East Pye Solar — Planning Inspectorate Reference EN0110014

Date: 10 September 2026

Subject: Formal Written Representation — Objection to East Pye Solar Project (EN0110014): Severe Harm to the Historic Setting, Immediate Approach, and Heritage Cluster at Hawes Green / Site 8

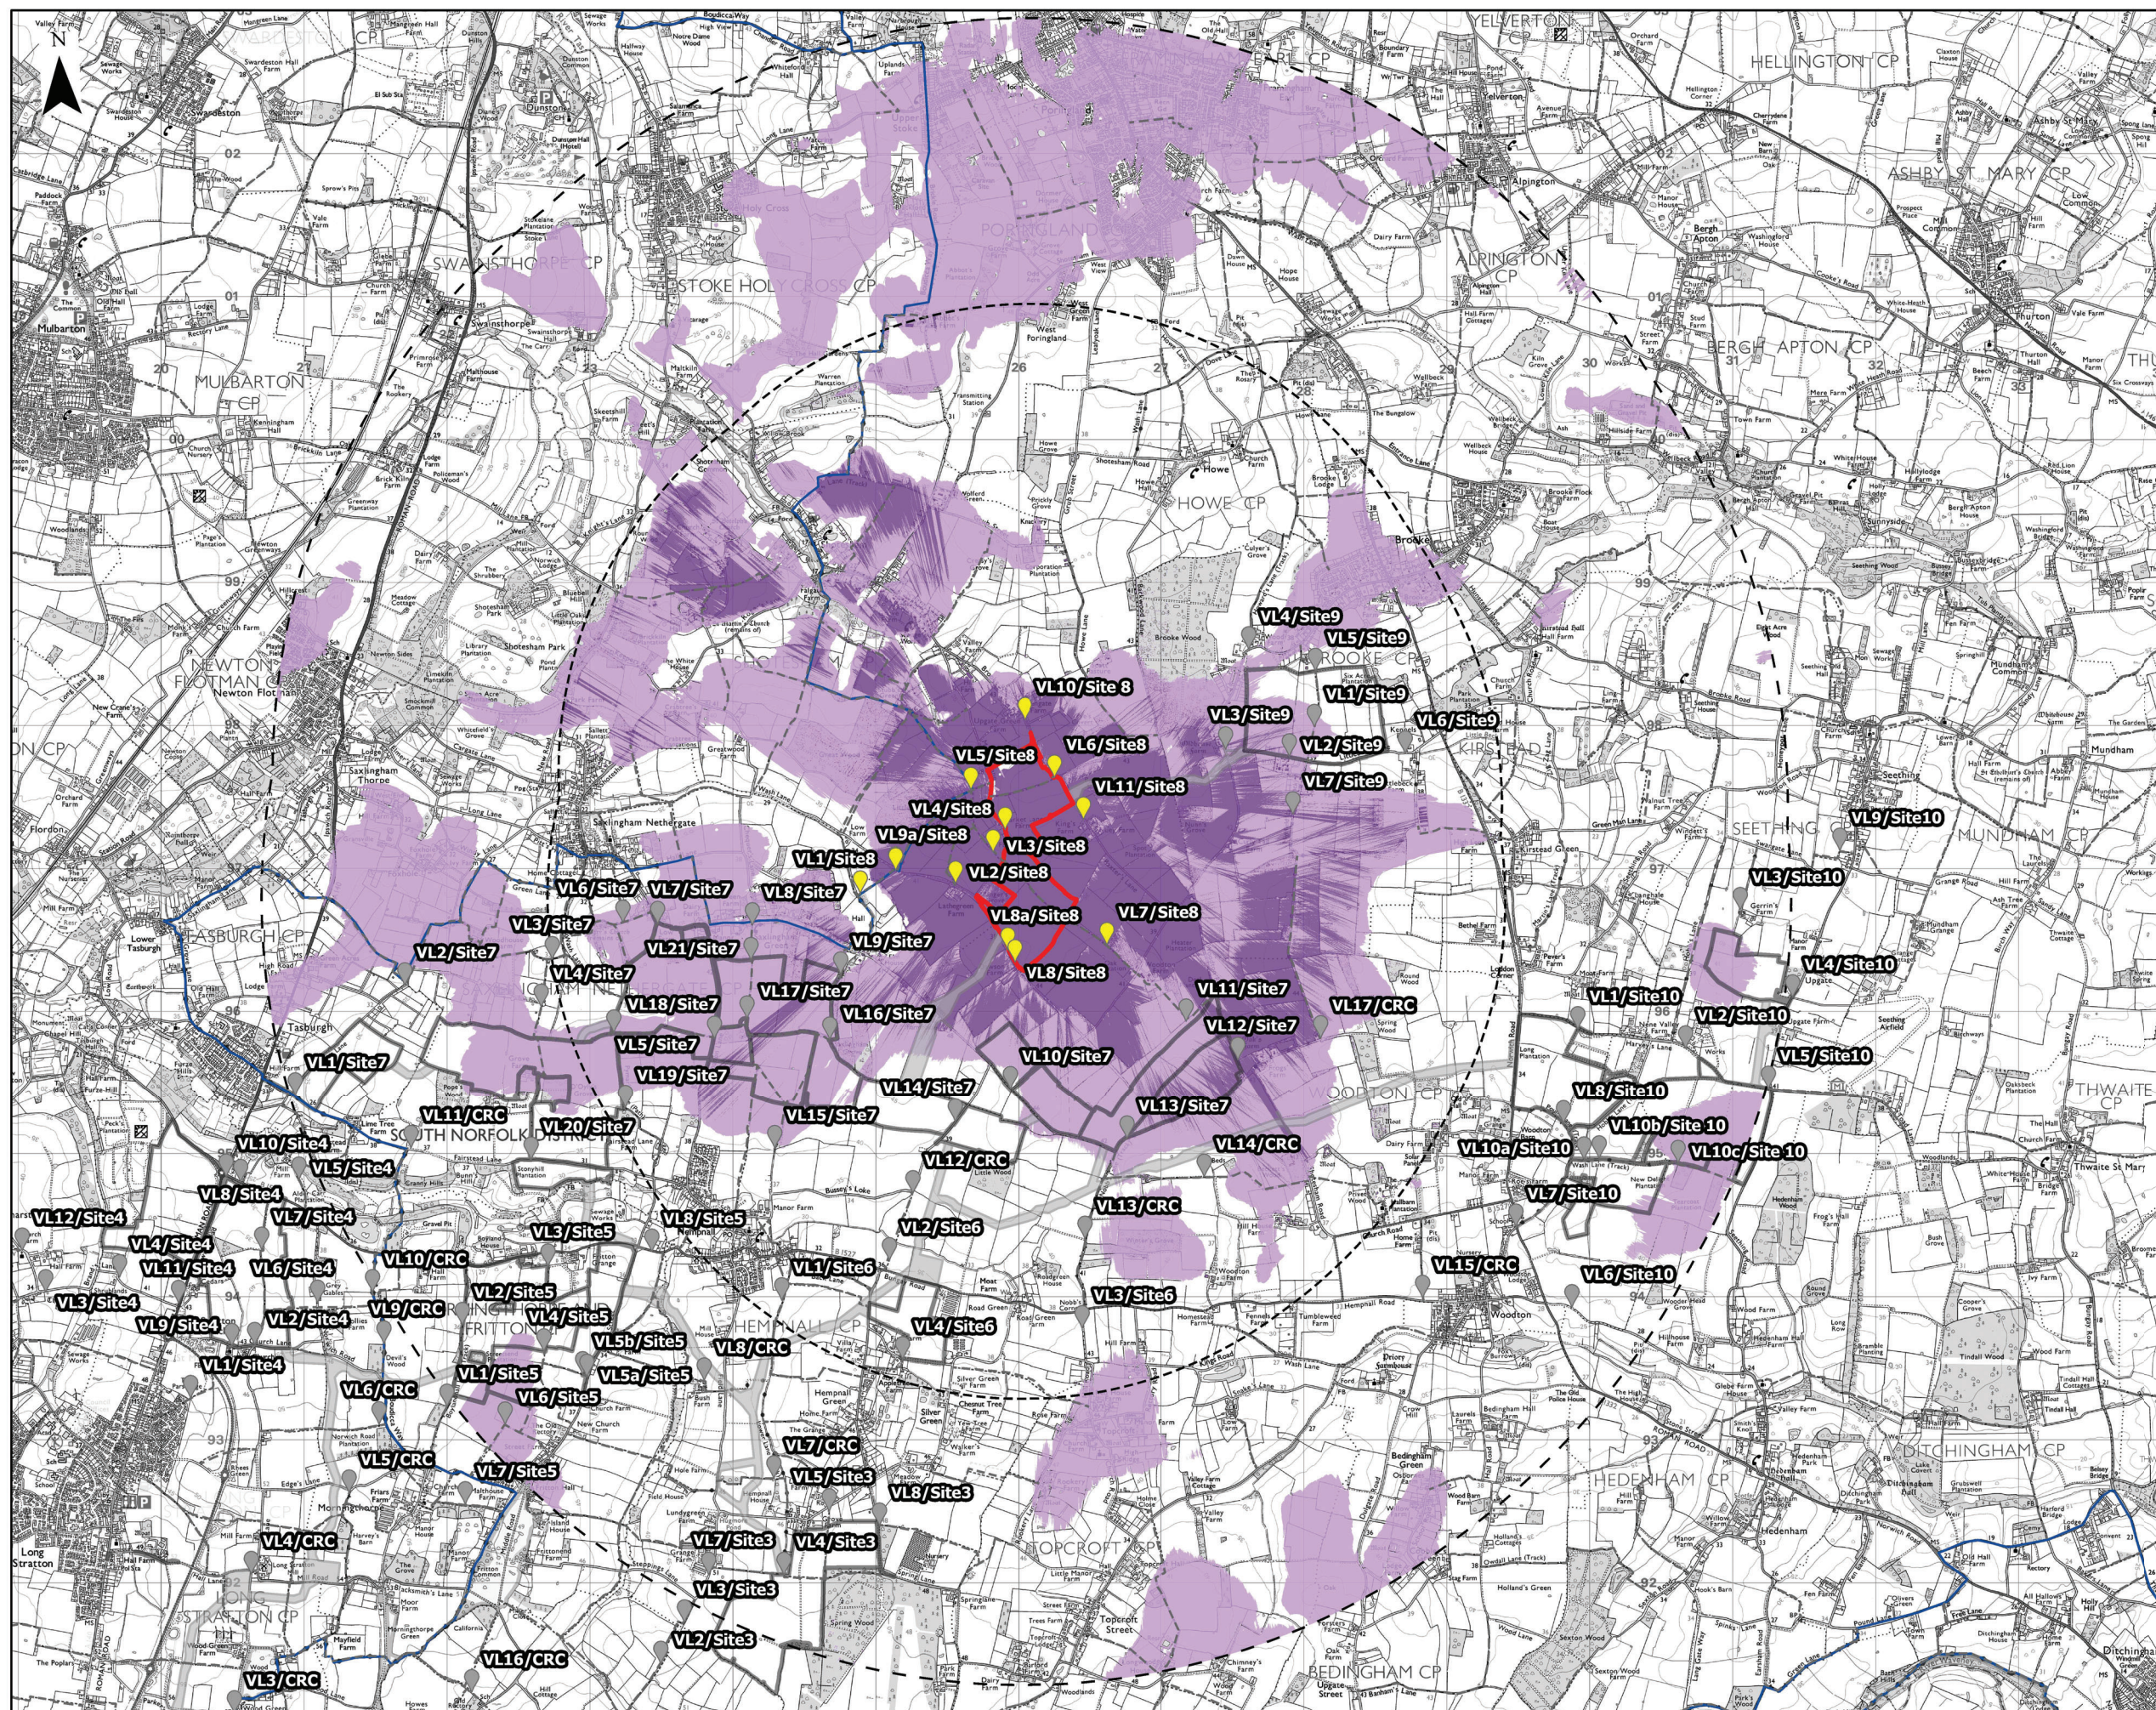
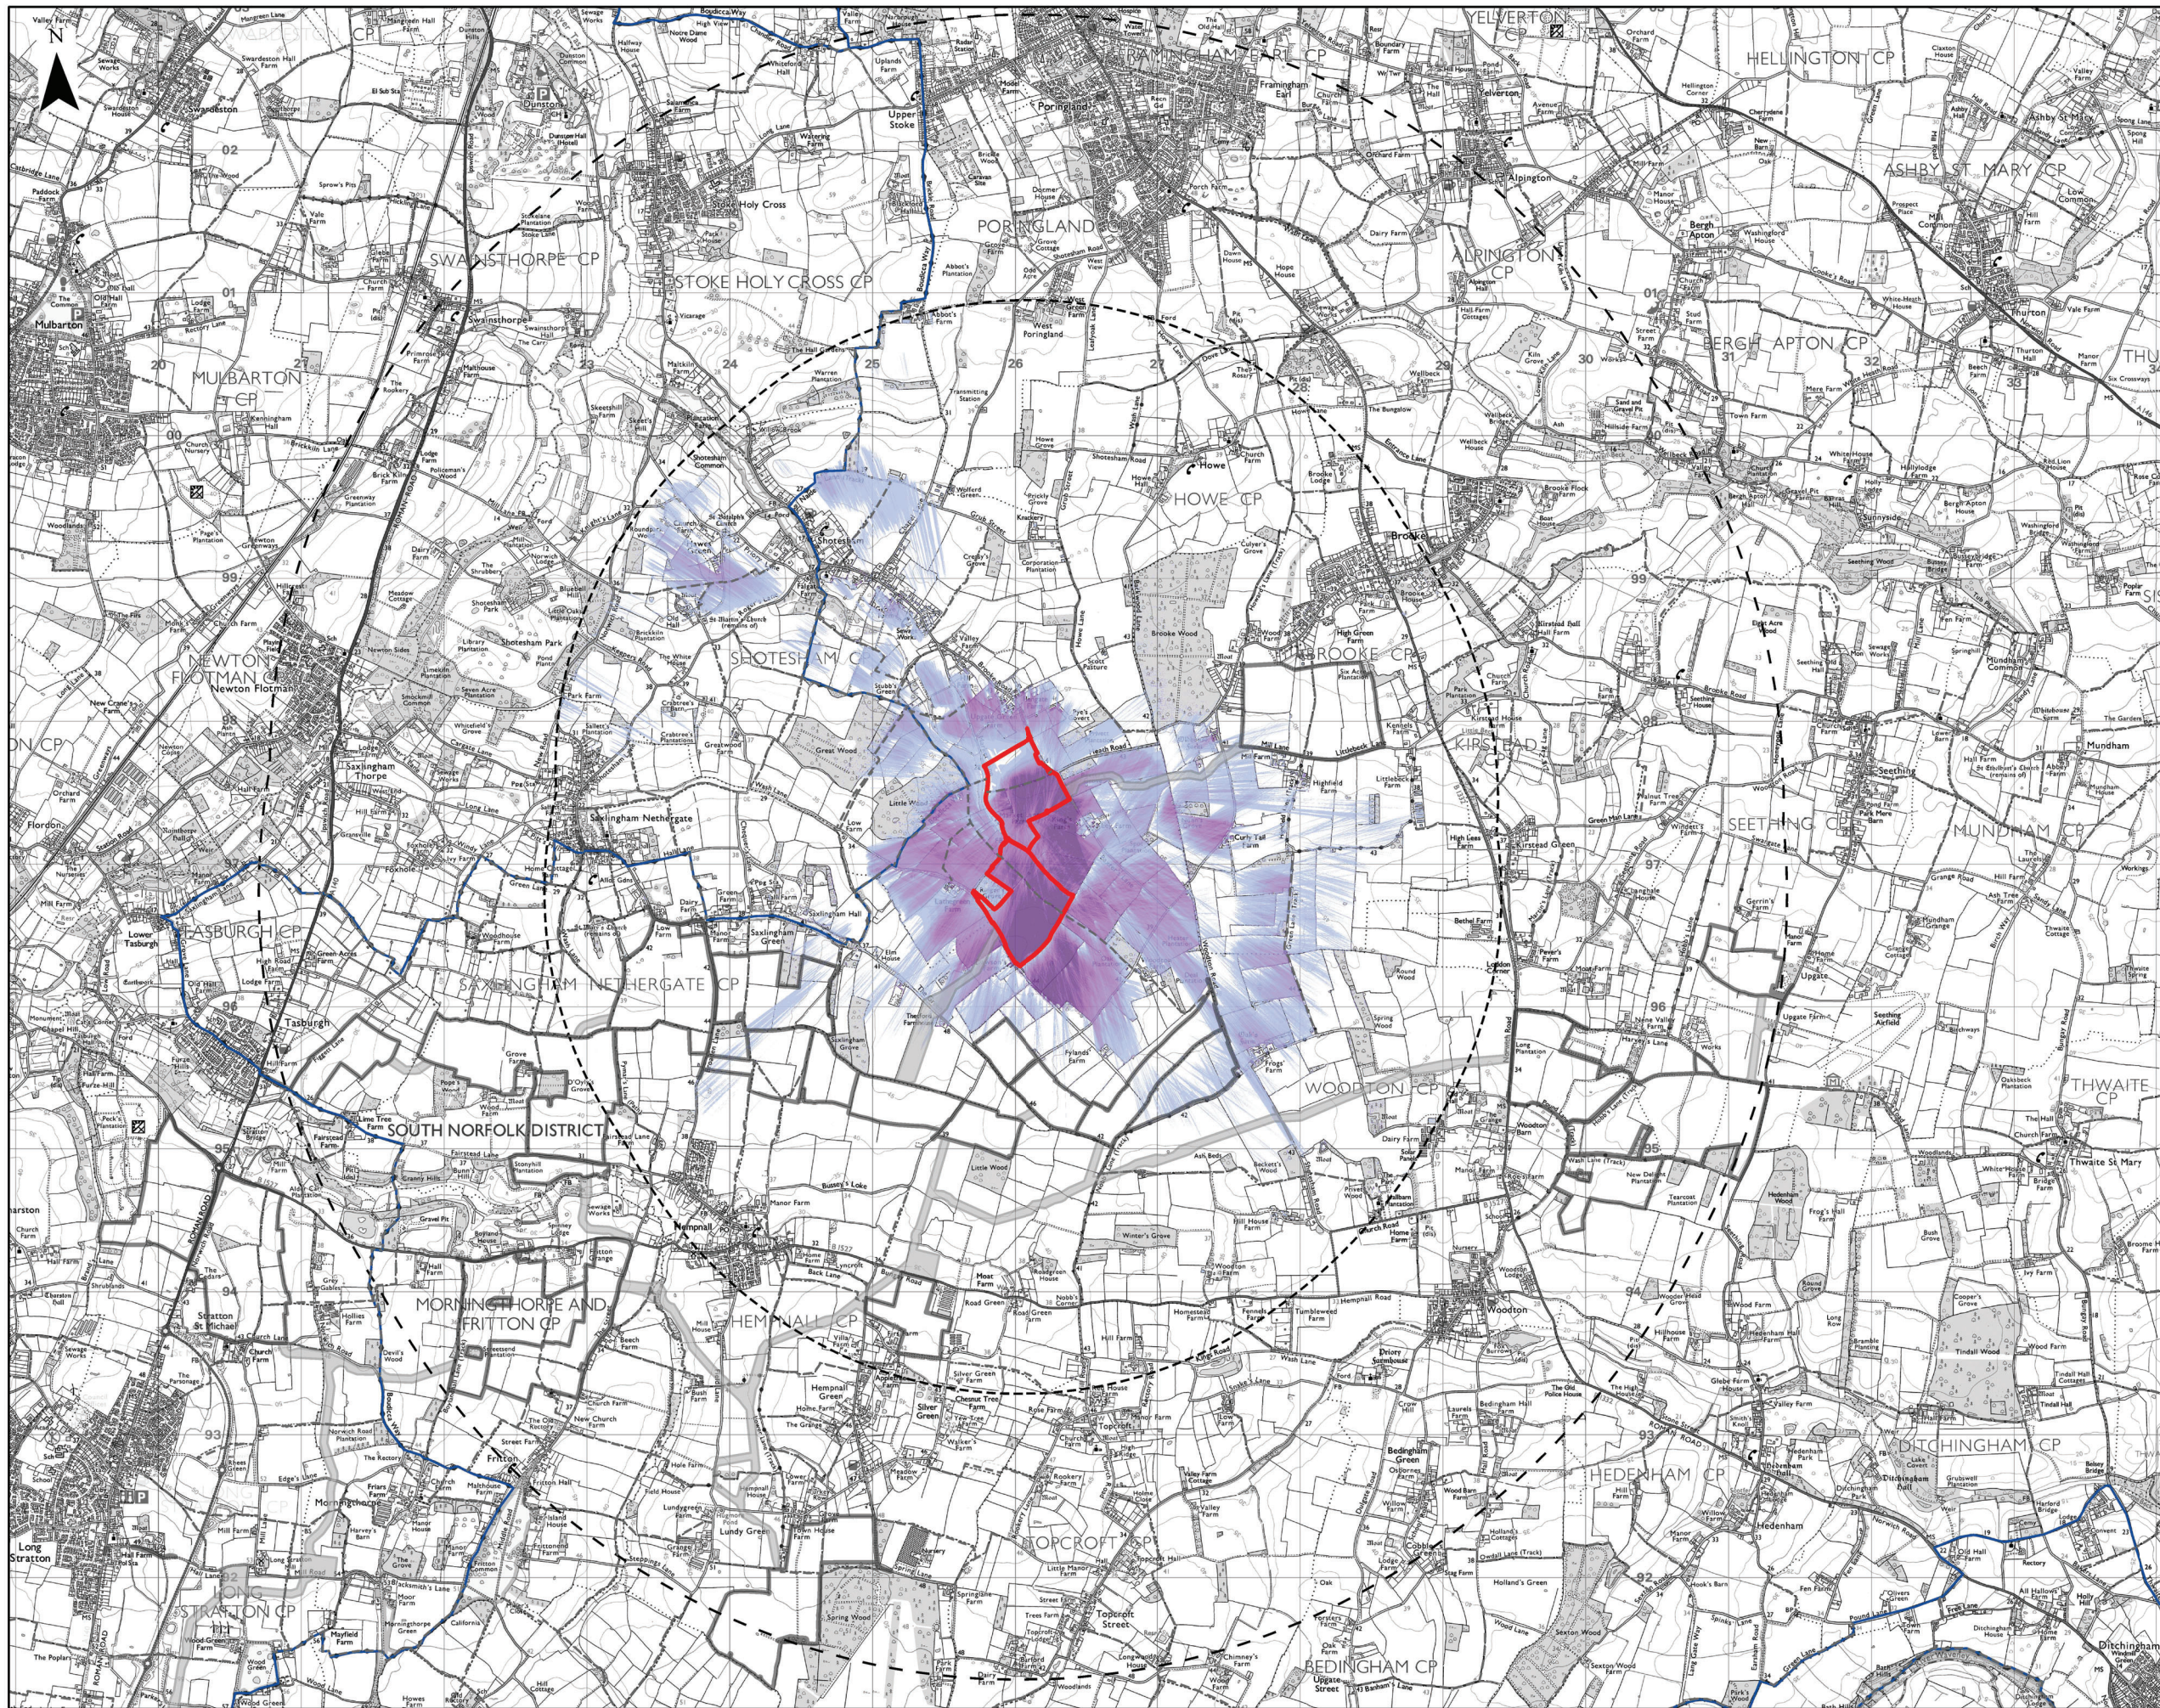
- (a) Require the Applicant to confirm whether Hawes Green falls within the ZTV for Site 8 (Figure 7.5.4) and, if so, to explain why no Residential Visual

Amenity Assessment has been conducted from this location, given that ES Chapter 7 paragraph 7.5.22 acknowledges Shotesham as a settlement from which visual effects are likely;
